***MODIFICATION REQUEST:
Commercial Development at 3 Murray
Rose Avenue, Sydney Olympic Park
(MP 11_0082 MOD 1)***

Request to modify Condition B4 Access for People
with Disabilities

Secretary's
Environmental Assessment Report
Section 75W of the
Environmental Planning and Assessment Act 1979

August 2014

Drawing Title
THE CHASE -
DETAIL PLAN

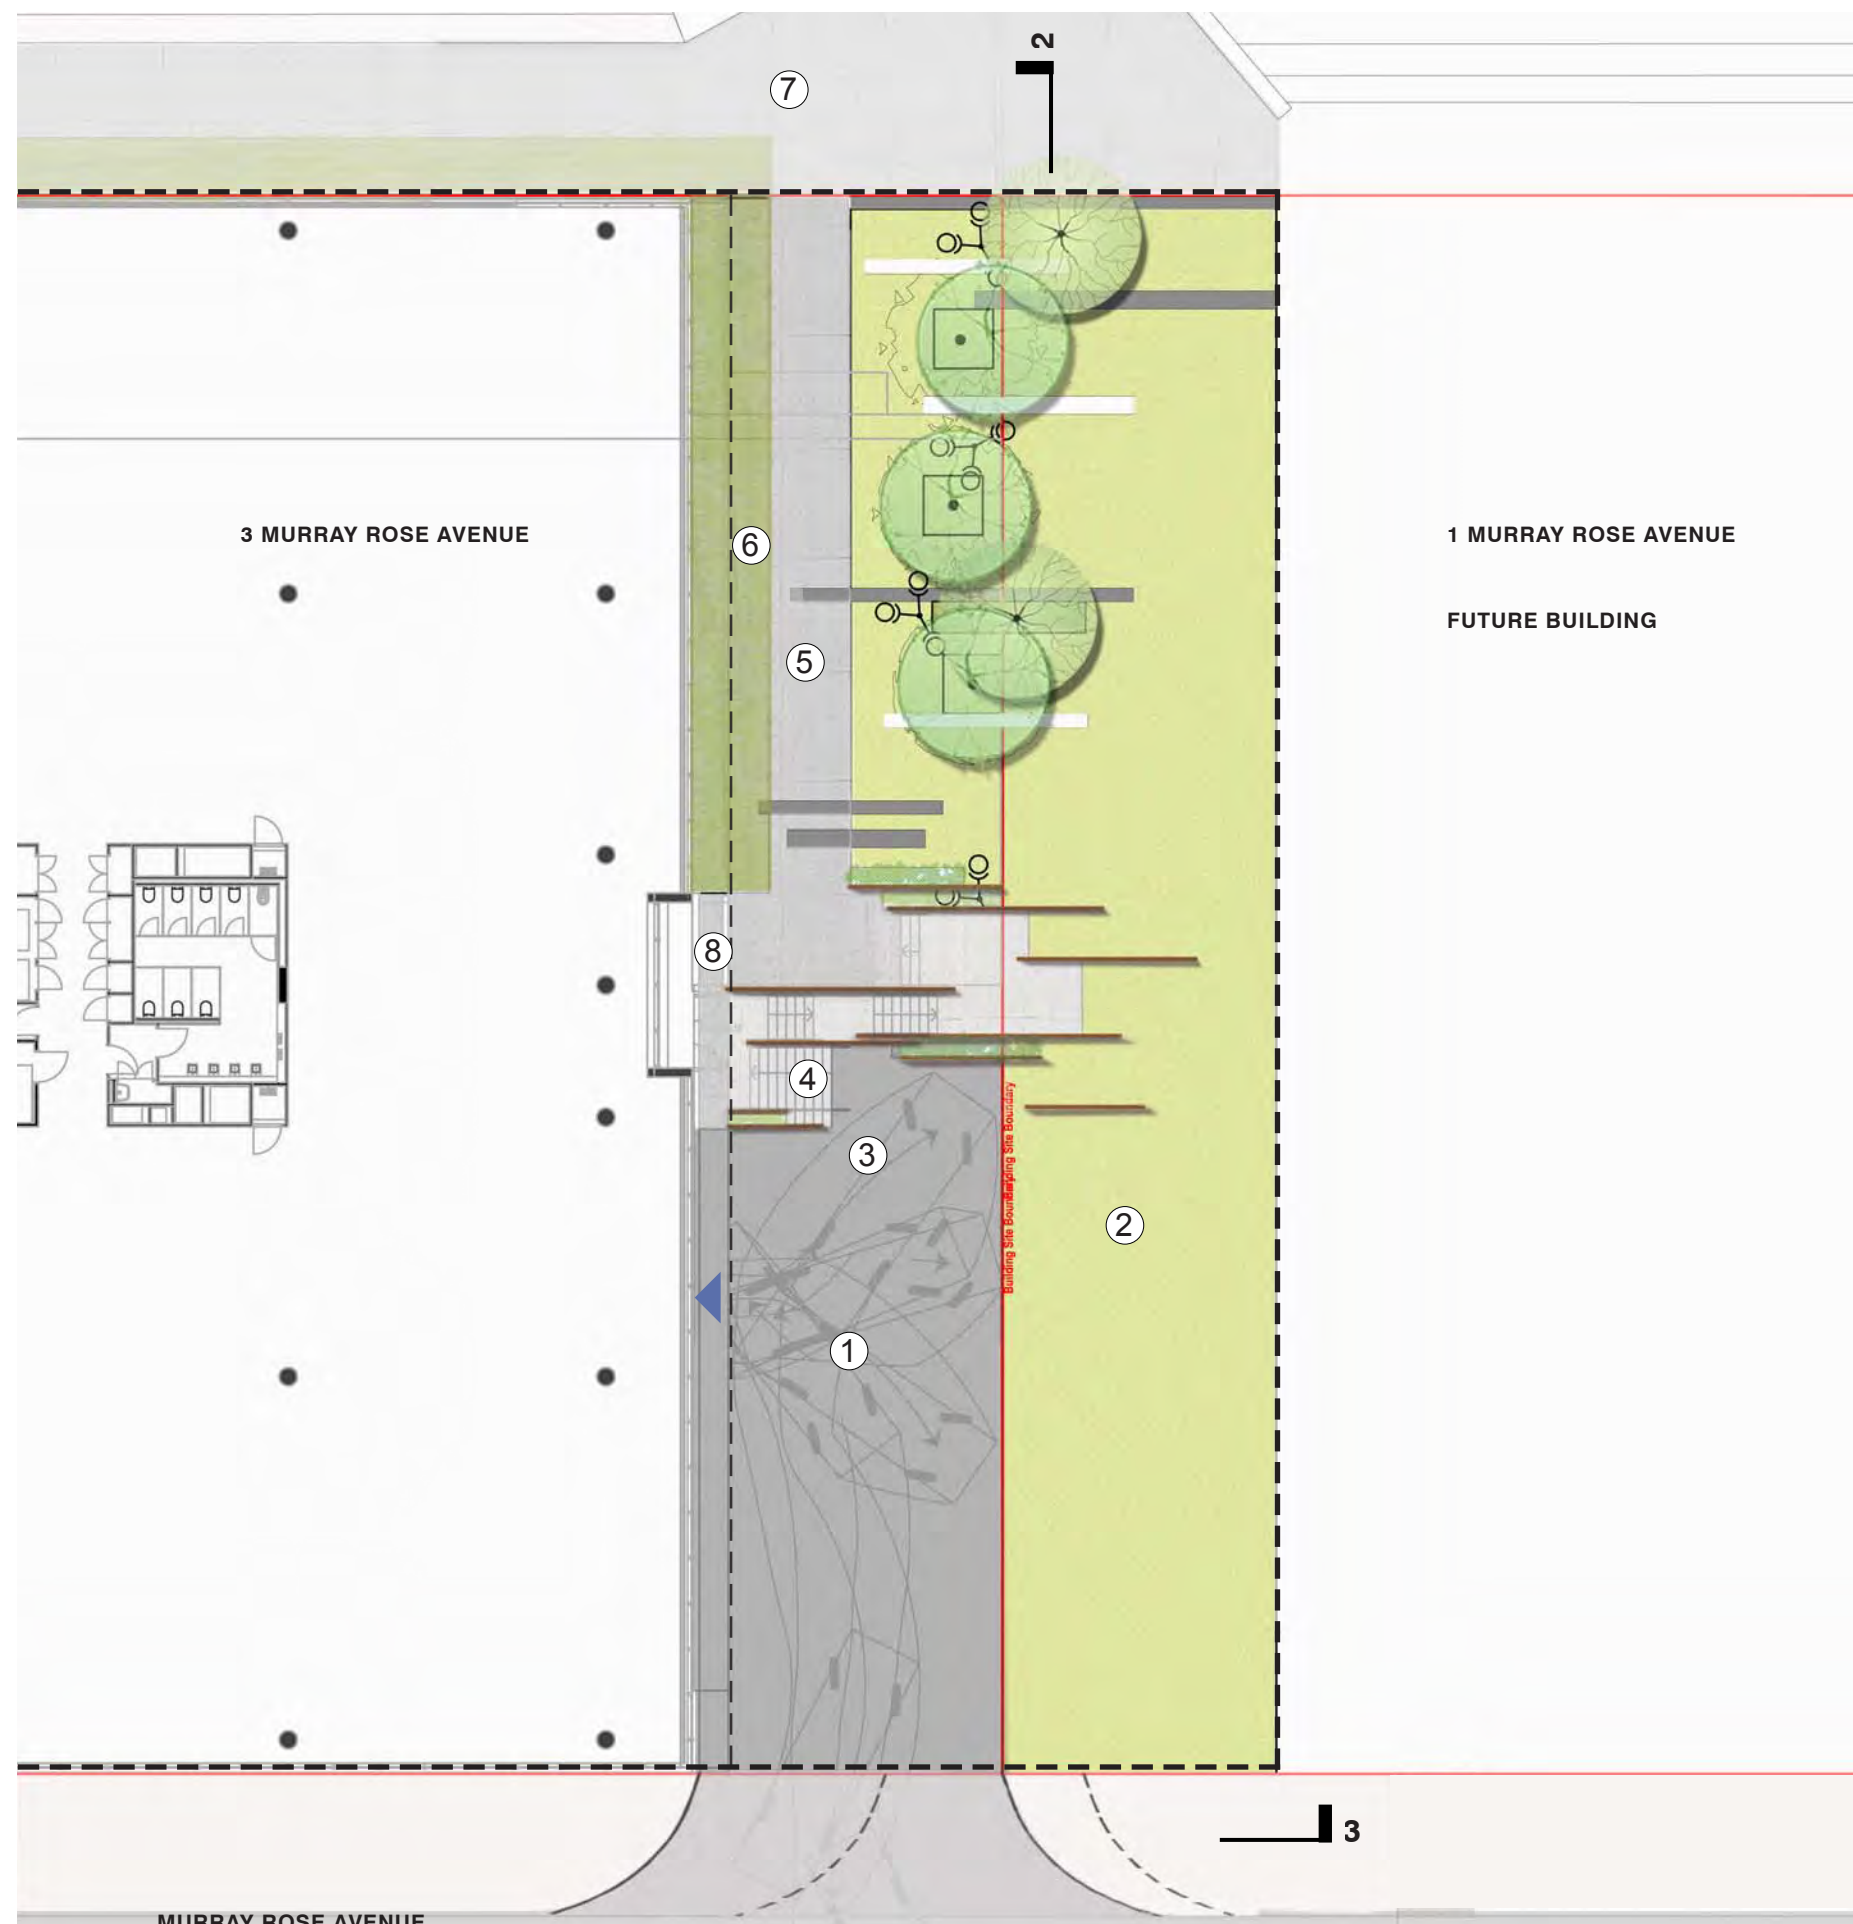
The approved design of 'the Chase' public domain does not meet the SOPA Access Guidelines and the proponent contends that a redesign of the area to comply would not be feasible due to spatial restrictions given the width and grade of the through-site link and the location of the loading dock driveway. The amendment proposes to remove reference to 'the Chase' from condition B4 as meeting accessibility requirements is not necessary as it is not the 'principal footpath' to the site, which would be via the main entrance from Murray Rose Avenue and 'the Cutting'. Furthermore, 'the Chase' is not appropriate as a main thoroughfare as the loading dock functions of 3 Murray Rose Avenue are located along 'the Chase'.

'The Chase' functions as a through-site link to provide access to Brick Pit Park as well as for emergency egress from the building. An alternate path of travel is available to pedestrians to Brick Pit Park from Parkview Drive and the main entry for 3 Murray Rose Avenue from the 'the Cutting' is identified as the most appropriate means of egress from the building in the event of an emergency situation. 'The Chase' also supports the loading dock for 3 Murray Rose Avenue and potentially the loading operations of the future 1 Murray Rose Avenue development (the remaining eastern portion of 1-5 Murray Rose Avenue) and would therefore perform as a secondary through-site link (see **Figure 4** for the current design of 'the Chase' and indicative future design upon delivery of 1 Murray Rose Avenue).

The department accepts that it would be unreasonable that a complete redesign of 'the Chase' be undertaken to ensure the area adheres to the accessibility requirements given alternate primary access paths to the main building and to the Brick Pit Park are available to persons with a disability. A redesign would also potentially have impacts on the design and function of the loading dock given 'the Chase' has a slope of approximately seven metres, which would require a minimum 140 metre ramp or walkway to meet accessibility requirements, and additional pedestrian traffic has the potential to generate increased pedestrian and vehicle conflict.

- B4. The building and landscaping, including paths within "the Chase", must be designed and constructed to provide access and facilities for people with a disability in accordance with the Building Code of Australia and SOPA Access Guidelines 2011.*
